BANORA POINT & DISTRICT RESIDENTS ASSOCIATION Inc.

Friday, 1 April 2011

**Re: DEP Reference 09_0166
Altitude Aspire 321 Lot Subdivision, Fraser Drive, Terranora.**

This is an objection to the application in its present form, primarily on grounds of unsatisfactory and unresolved access.

PLAN SHOWING
PROPOSED SUBDIVISION LAYOUT
& DESIGN CONTOURS

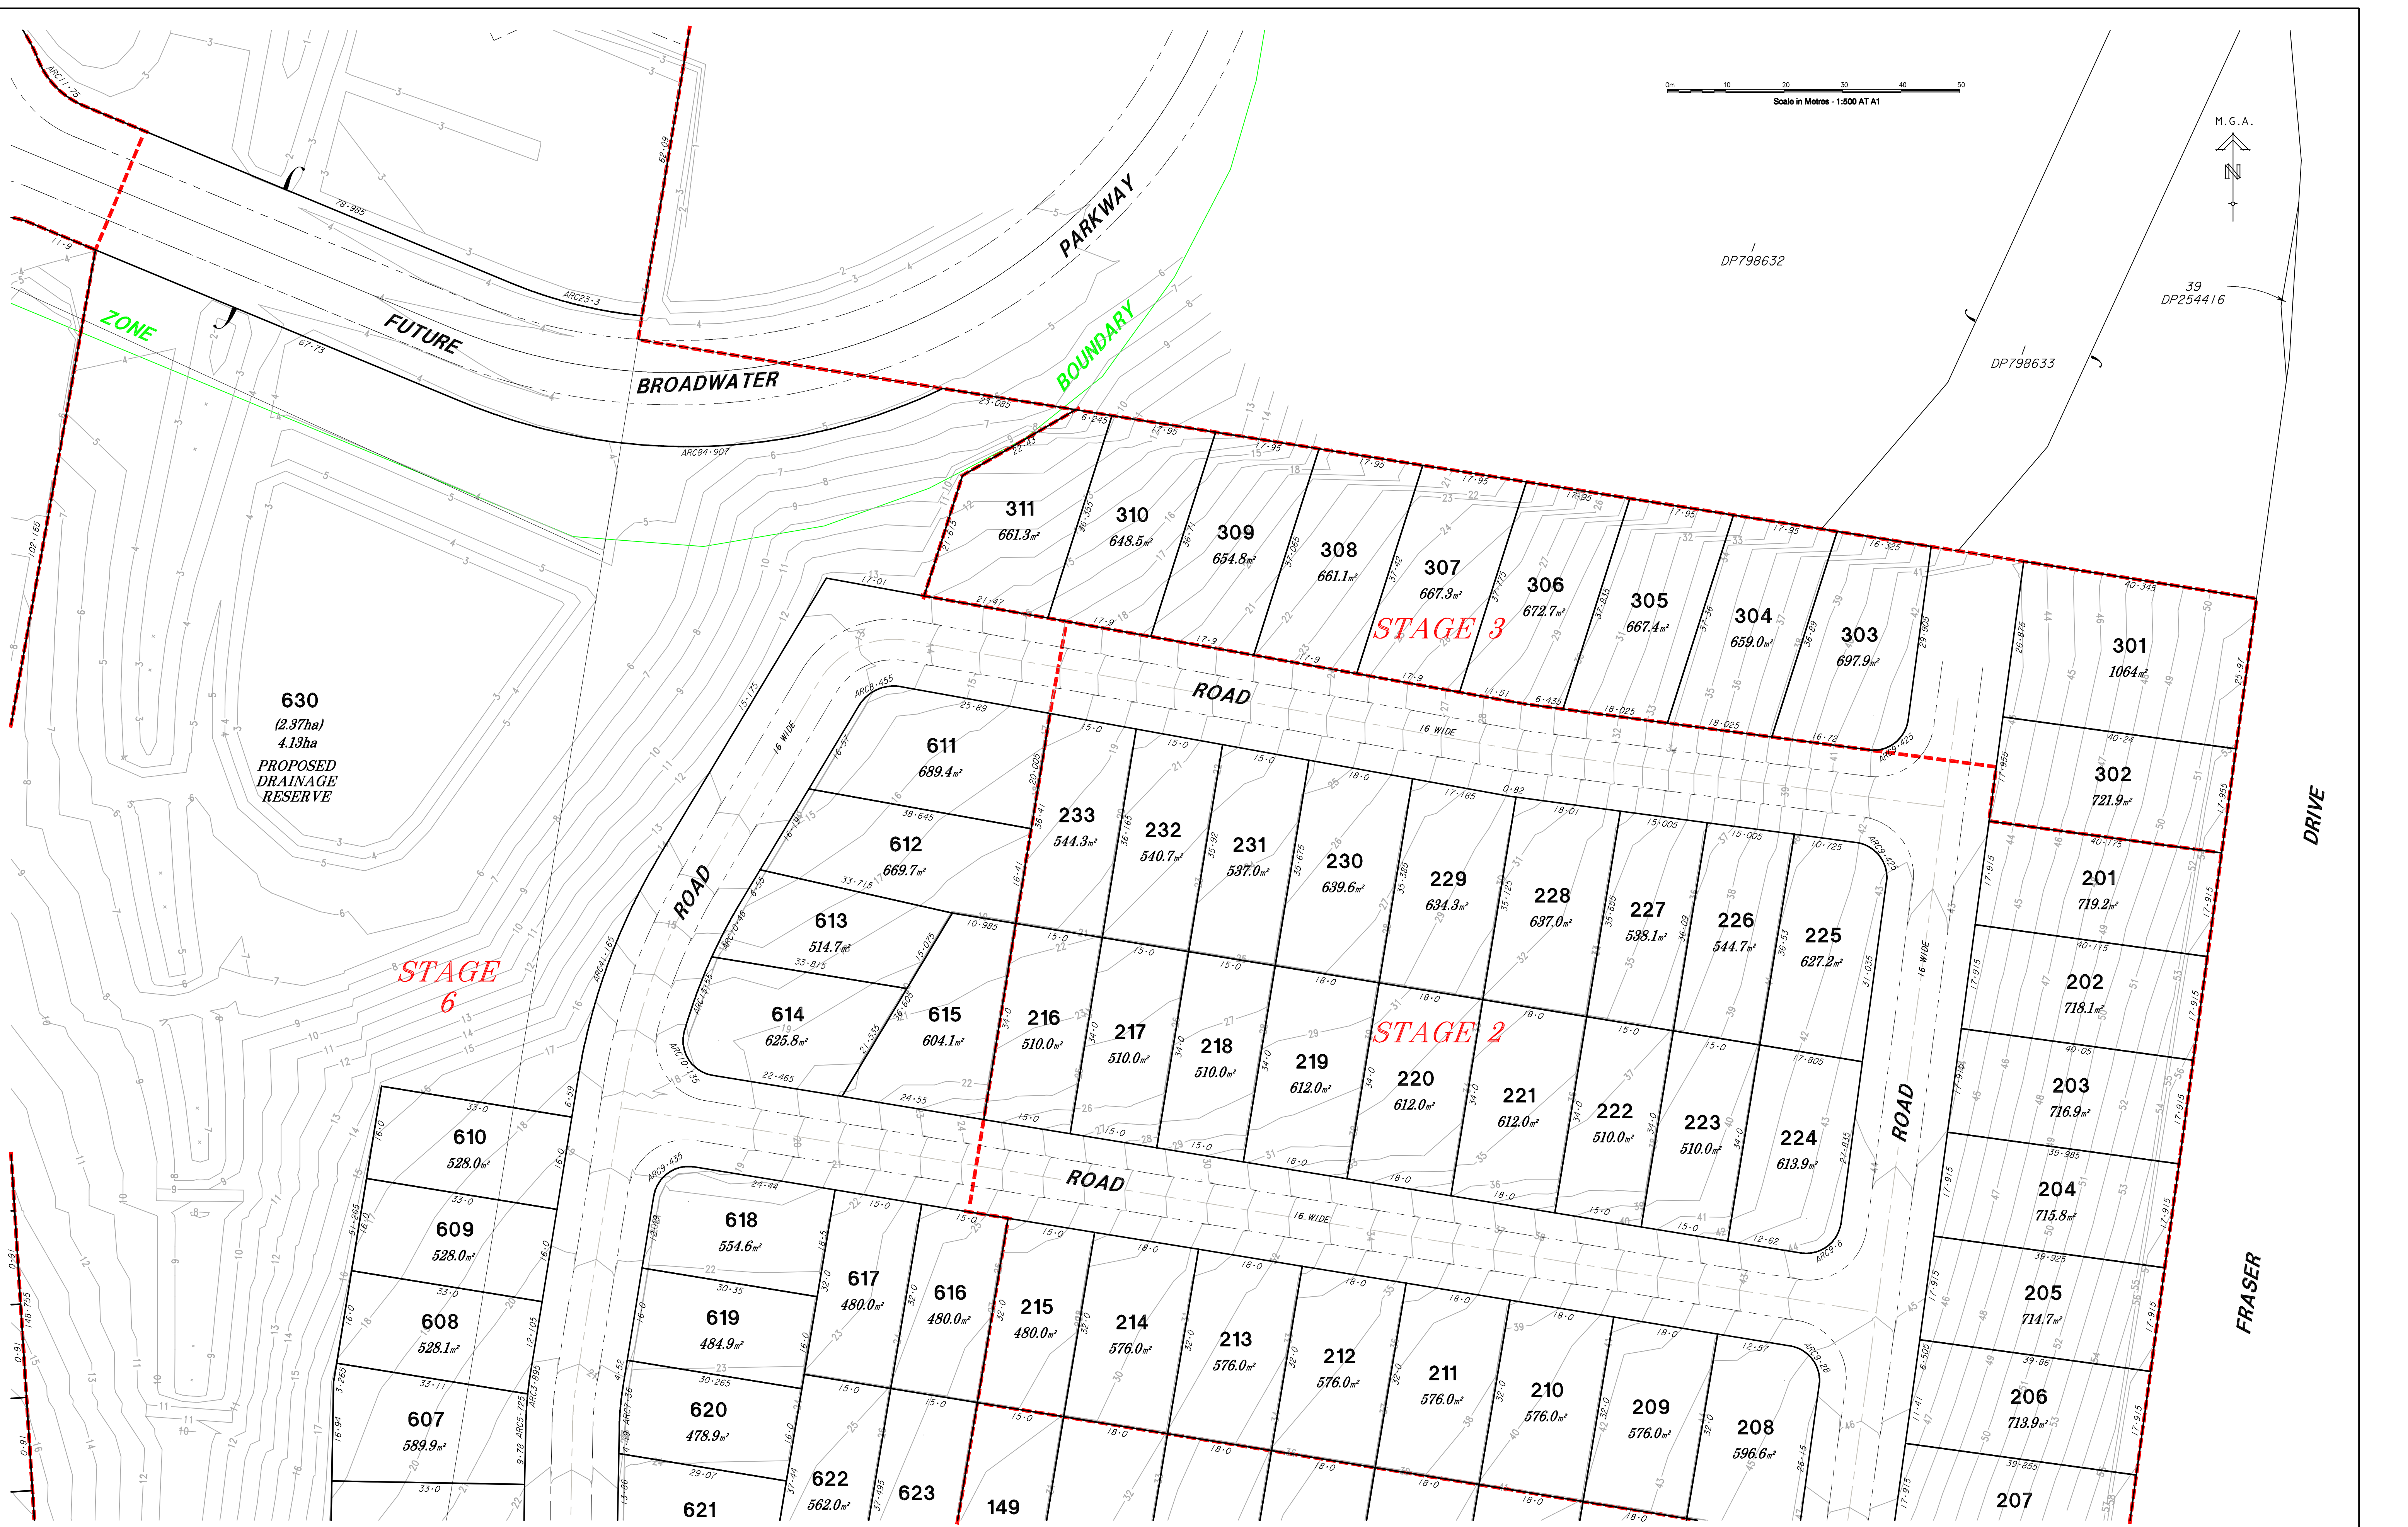
Instead, the application proposes a "temporary" link with Fraser Drive via a Right of Carriageway (ROW) at the most southerly point of their development. During the development of Altitude Aspire, other links with roads have been proposed (Parkes Lane and Market Parade). The final stage of Altitude Aspire, Stage 11, is the closure of the ROW.

1. Access to and from the estate has not been determined.
2. The access corridor proposed under Tweed LEP 2000 appears to have been abandoned without justification.
3. No costings for the road can be assessed in the absence of design plans.
4. Method of payment for the road and time of construction are not known and no commitment for construction made.
5. The proposed "temporary" access road via a ROW to Fraser Drive is unsatisfactory. This will be the only access to the estate until Stage 5 when an equally unsatisfactory link is proposed to Market Parade.
